DESIGN & METHOD STATEMENT

Non Material amendment

Project – Proposed two storey Chalet Extension @ 12 Cavendish Road Bognor PO21 2JW

Approved Planning application – BN/48/20/HH dated 22nd May 2020

Title
APPROVED ELEVATIONS AND ROOF PLAN

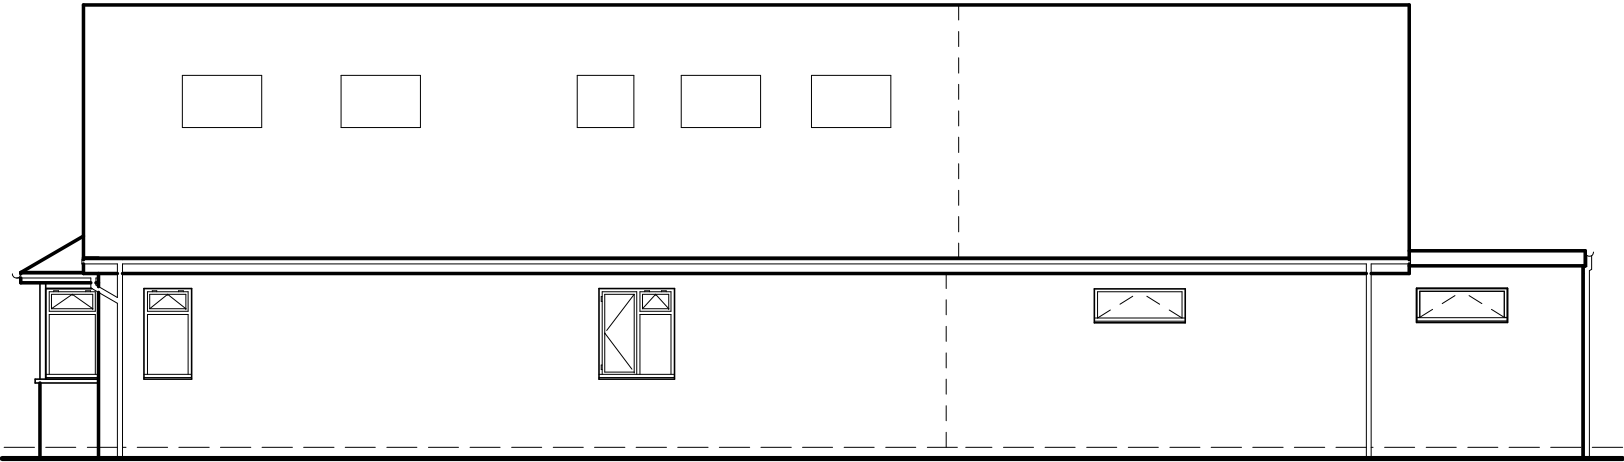
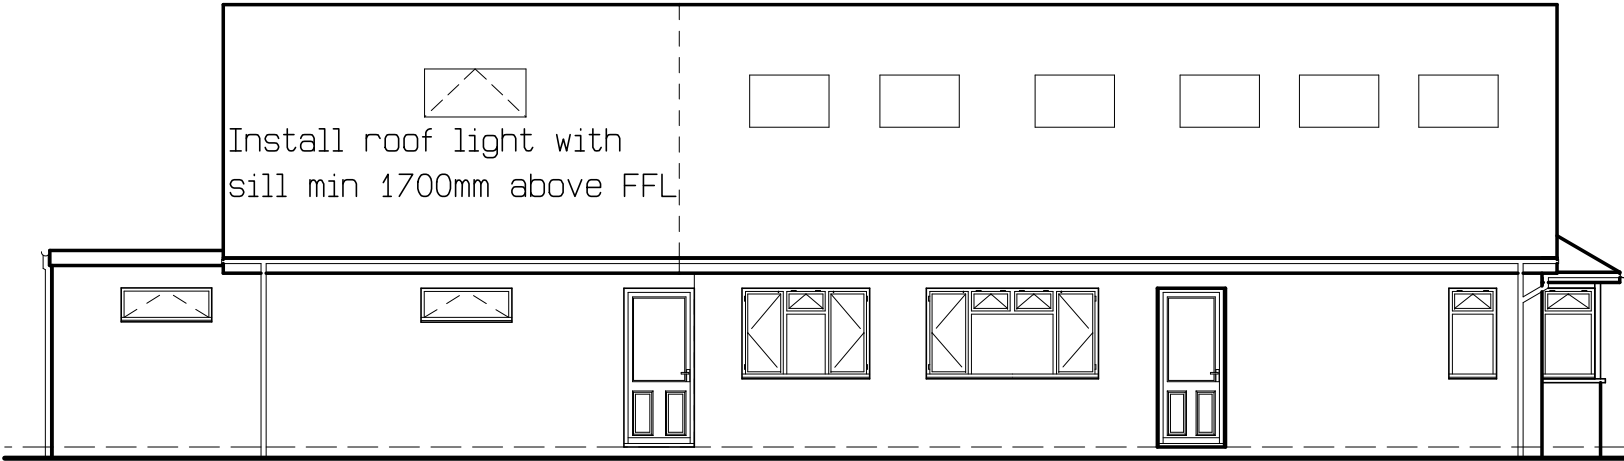
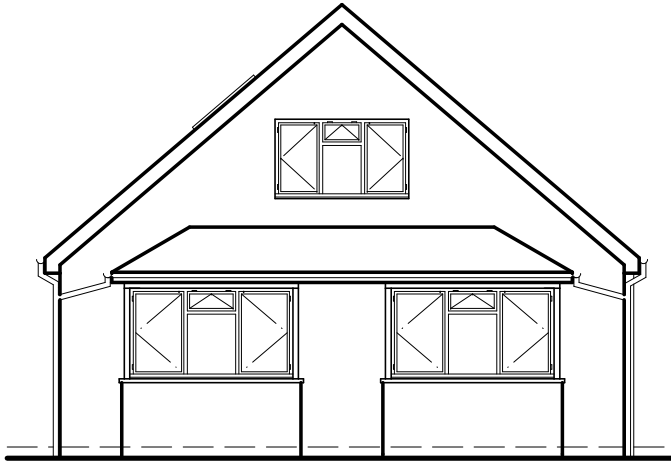
Approved Rear North facing Elevation - Ground Floor

To amalgamate the approved Patio doors and the approved French Doors into one larger Patio sliding door unit with a nominally increased overall width.

Approved Rear North facing Elevation – 1st Floor

Approved large full height opening windows to be replaced with Bi-fold inward opening doors of almost same opening size complete with a Juliet balcony – 1100mm high toughened glass glazed screen / fall protection external unit secured back to external wall face.

Approved East Side Elevation - Ground Floor

This elevation has 2 No high level 1200mm long windows spread along extension [position varies plans to elevations] – one of these is in new internal room area and not providing sufficient daylight – has been extended to a 3300mm long unit, the other one in the rear corner has been increased to a full height unit to give more of a “garden room” feel to rear of Lounge.

Approved West Side Elevation - Ground Floor

Two 1200mm long high level windows as East side [position vary on approved GF plan and elevations] – one to match end of Lounge / garden room on east side, other as full height unit to provide light and space to Utility area and light back into Kitchen as one of two old Kitchen windows blocked up.

Title
PROPOSED FIRST FLOOR PLAN

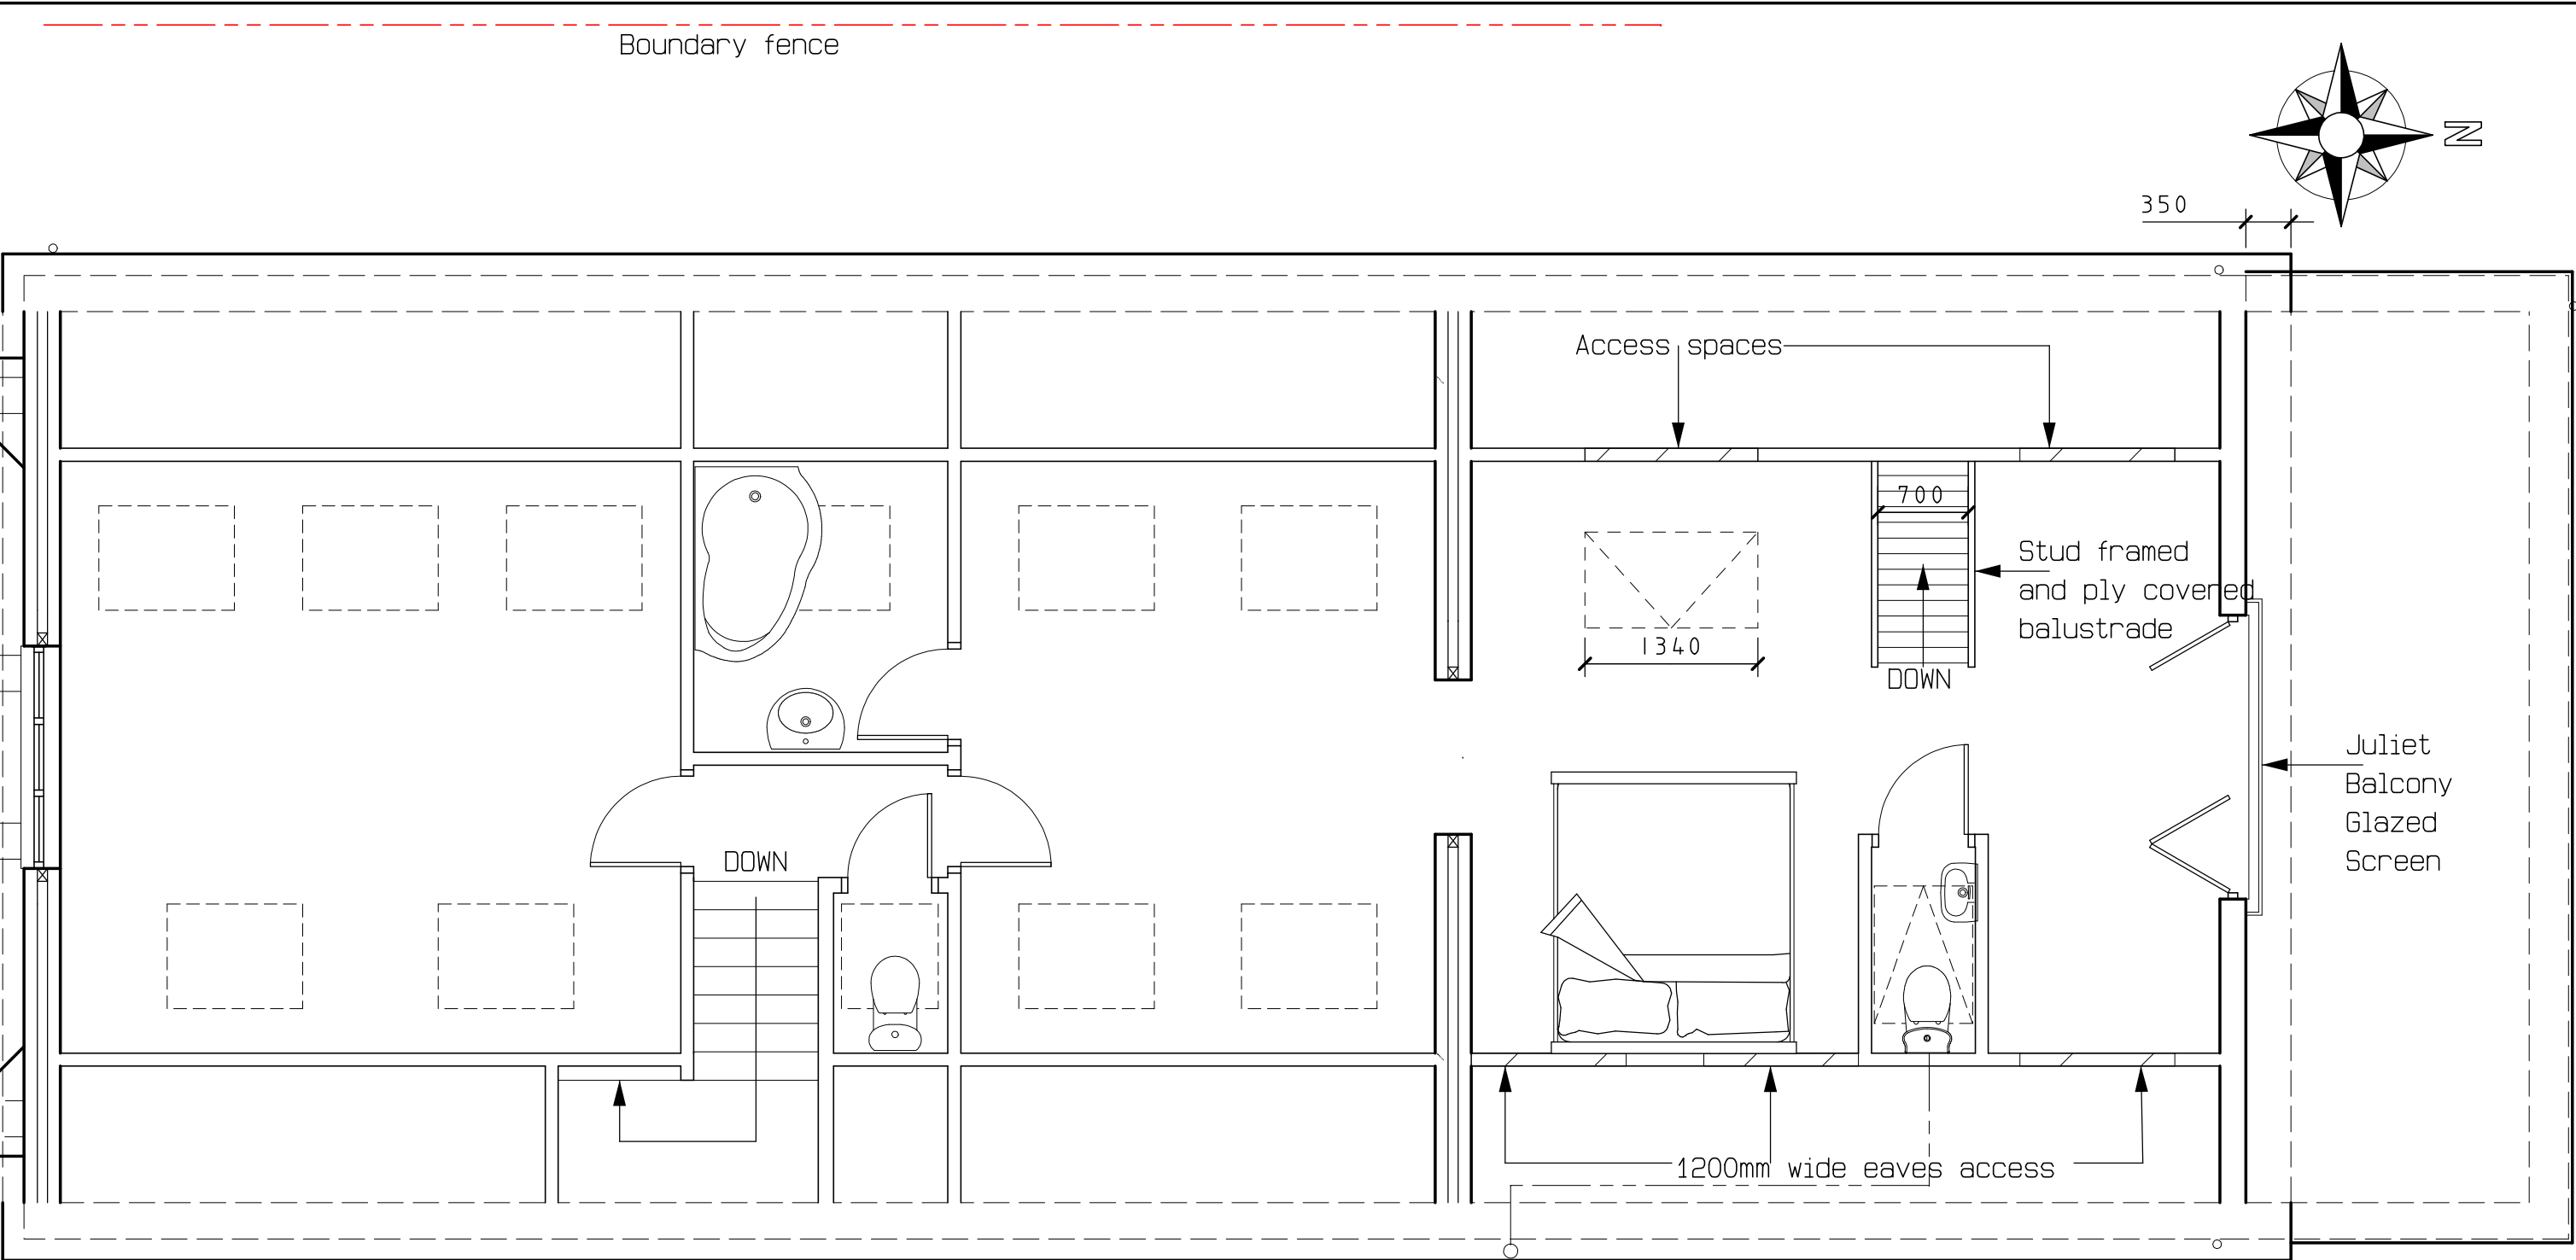
Bedroom ensuite WC / basin – to provide additional Velux as per larger approved Bedroom unit ie sill not less than 1700mm from FFL including opaque glazing.

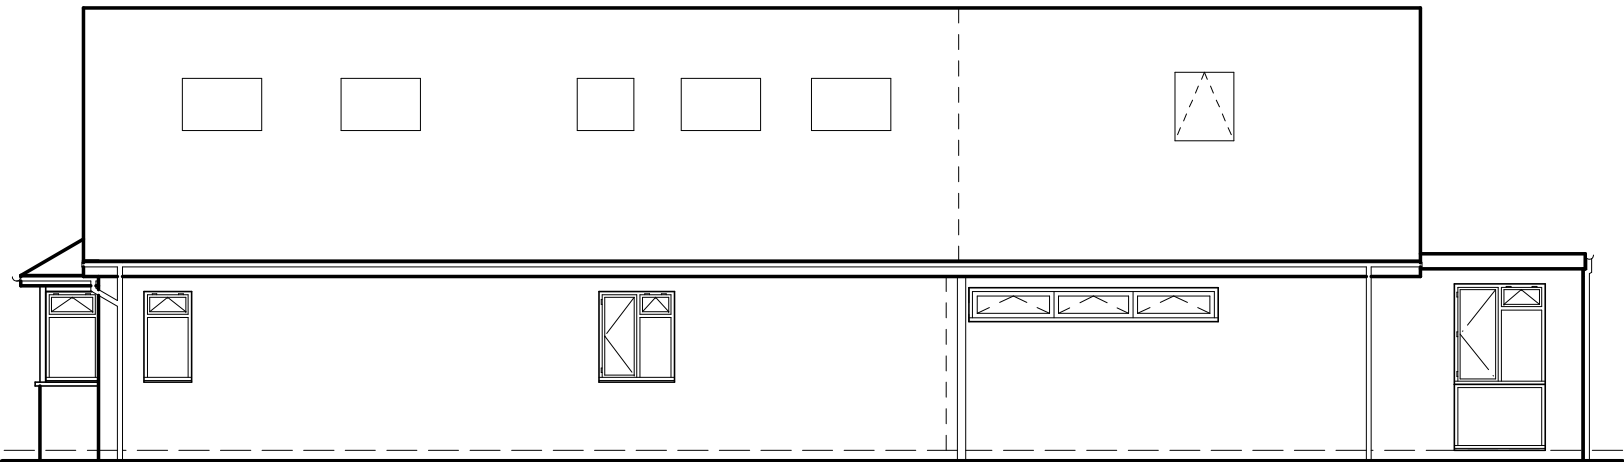
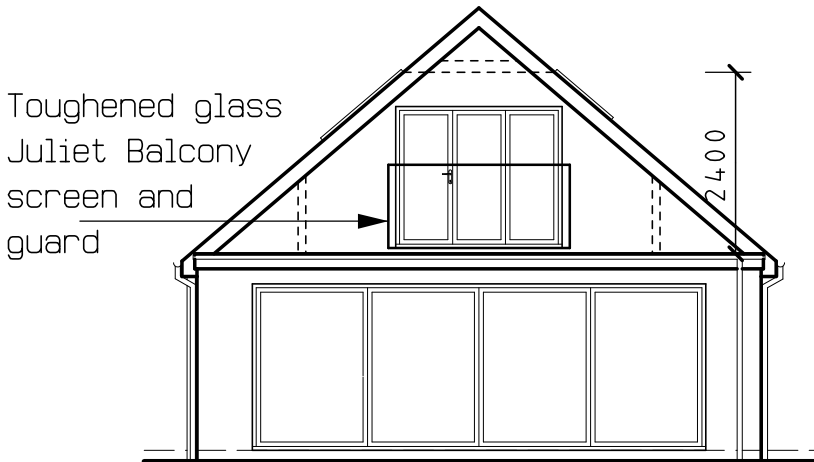
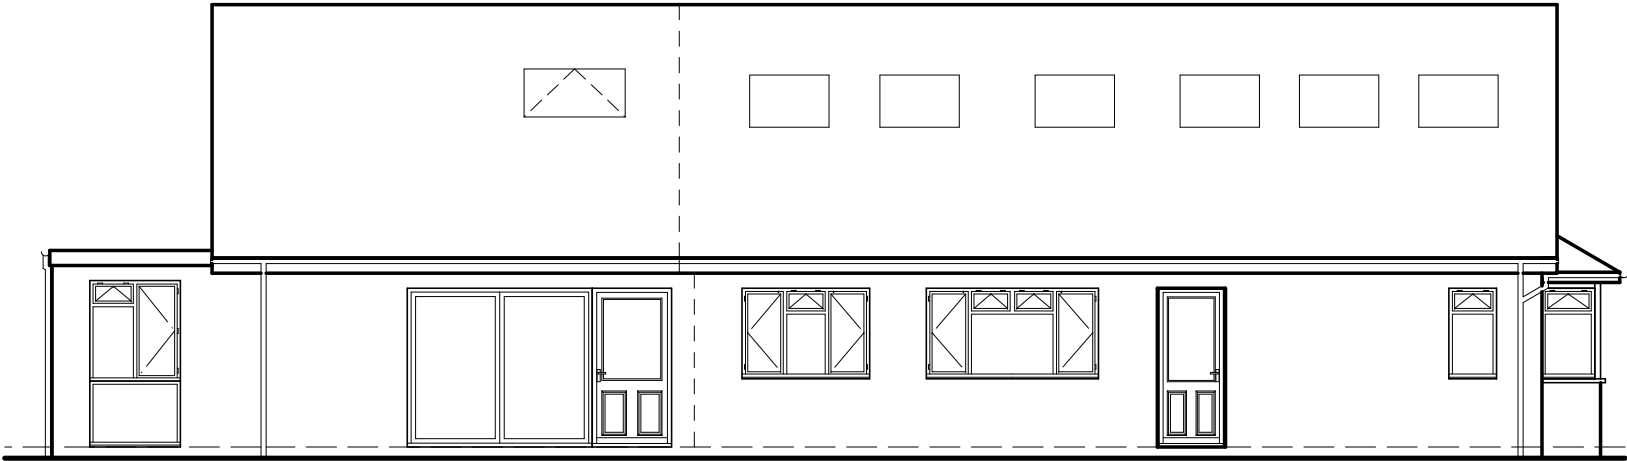
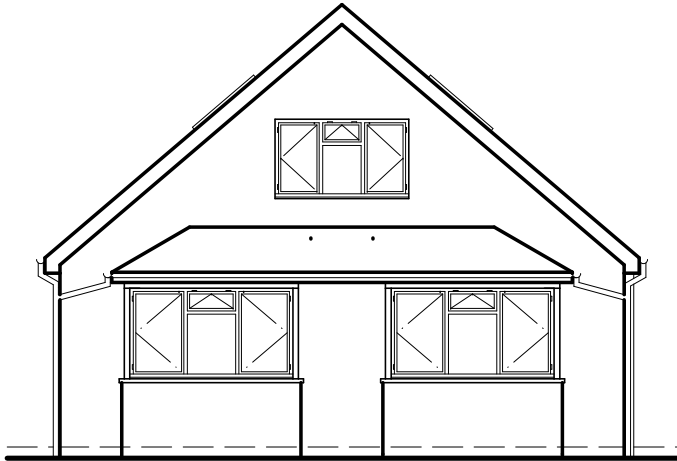
East Side Elevation – 1st Floor – additional
